**WELWYN HATFIELD BOROUGH COUNCIL
EXECUTIVE DIRECTOR - PLANNING, PUBLIC PROTECTION AND GOVERNANCE**

Application No: 6/2022/0115/PN8
Location: The Old Cottage 86 Bell Lane Brookmans Park AL9 7AY
Proposal: Prior approval for single storey rear extensions 8m in depth, and 3m in height.
Officer: Ms Elizabeth Mugova

Recommendation: Prior Approval Not Required

PROJECT DESCRIPTION	Proposed Rear Extensions
SITE ADDRESS	86 Bell Lane, Brookmans Park AL9 7AY
DRAWING TITLE	Proposed Ground Floor Plan
PROJECT STATUS	Planning Permission
DRAWING SCALE	1:100 @ A3
DATE	Jan. 2022
DRAWN BY	CHECKED BY
REVISION	0
DRAWING NUMBER	413/05

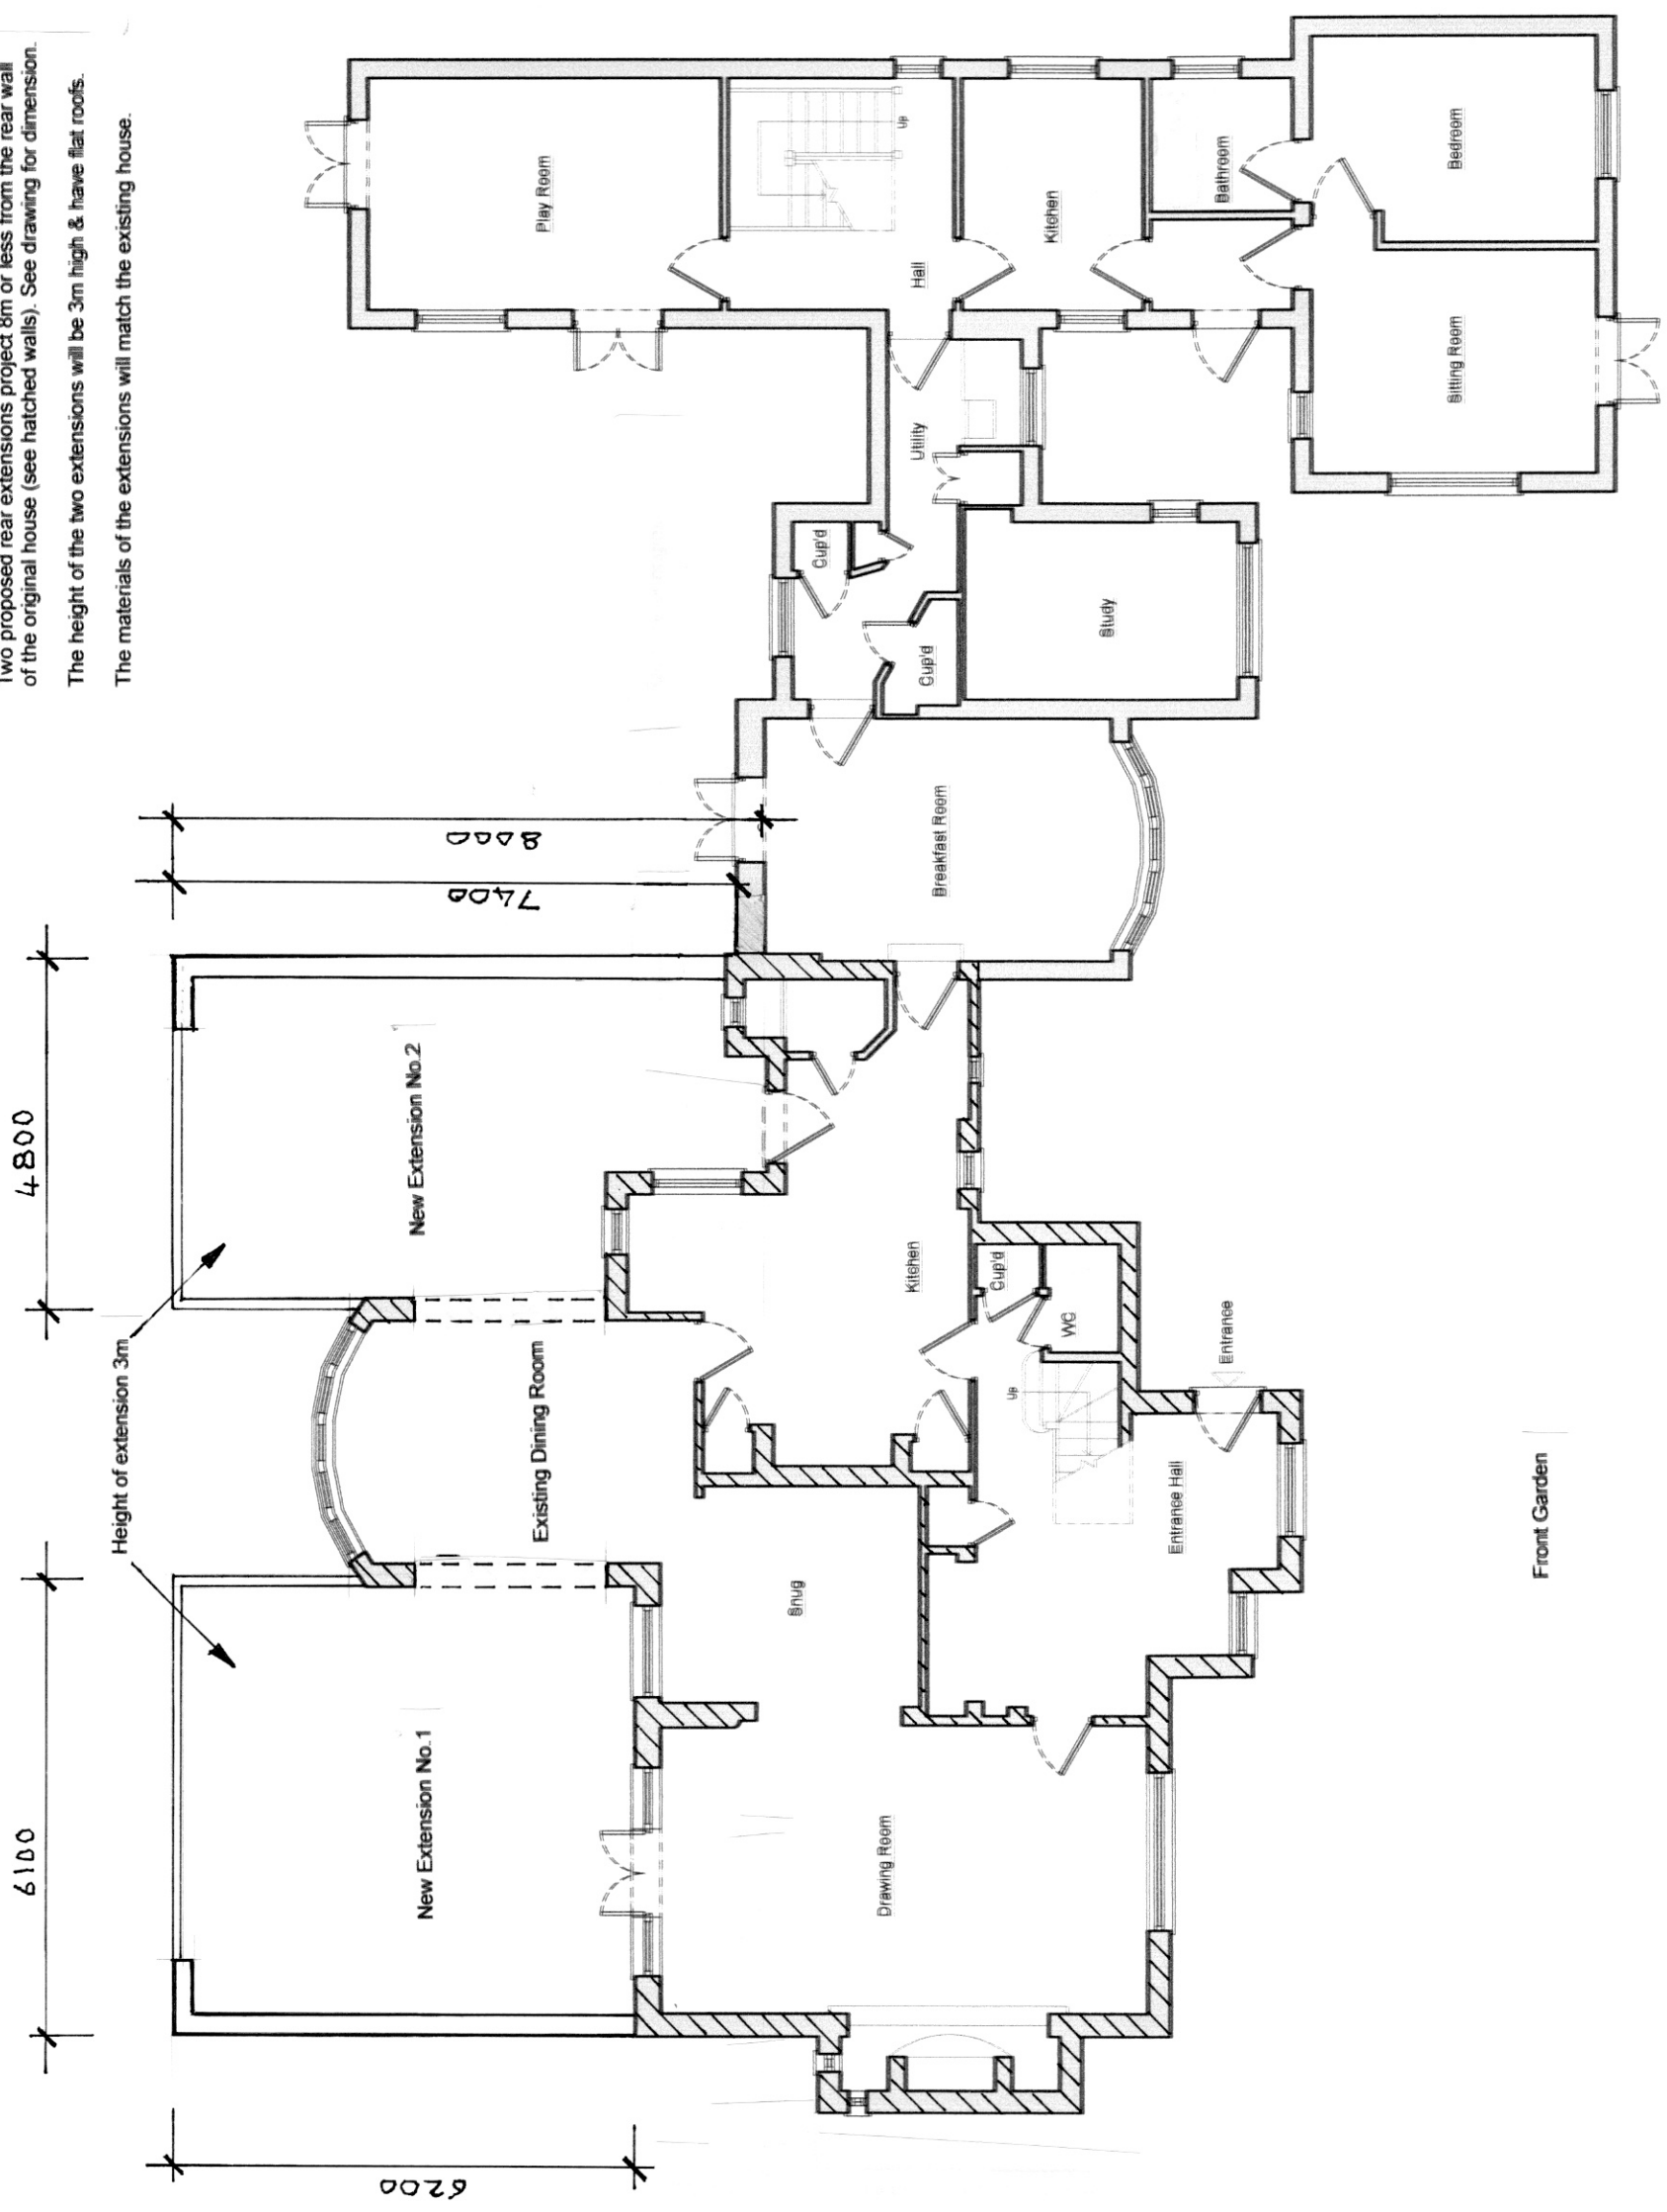
(f) would, subject to paragraph (g), the enlarged part of the dwellinghouse would have a single storey and— (i) extend beyond the rear wall of the original dwellinghouse by more than 4 metres in the case of a detached dwellinghouse, or 3 metres in the case of any other dwellinghouse, or (ii) exceed 4 metres in height	Y - 7.5m N	N

(i) (i) Would it extend beyond the rear wall of the original dwellinghouse by up to or the equivalent of 8 metres in the case of a detached dwellinghouse, or 6 metres in the case of any other dwellinghouse	Y – 7.5m		
(ii) (ii) Be less than or equal to 4 metres in height	Y		
Have any representations been received from adjoining premises	N

granted in 1988. No other history of the property has been found and therefore, the single storey side projection indicated as part of the kitchen on the submitted plans is taken to be part of the original dwelling and the rear projection. Furthermore, the proposal as submitted meets the requirements for permitted development rights, therefore full planning application would not be required.
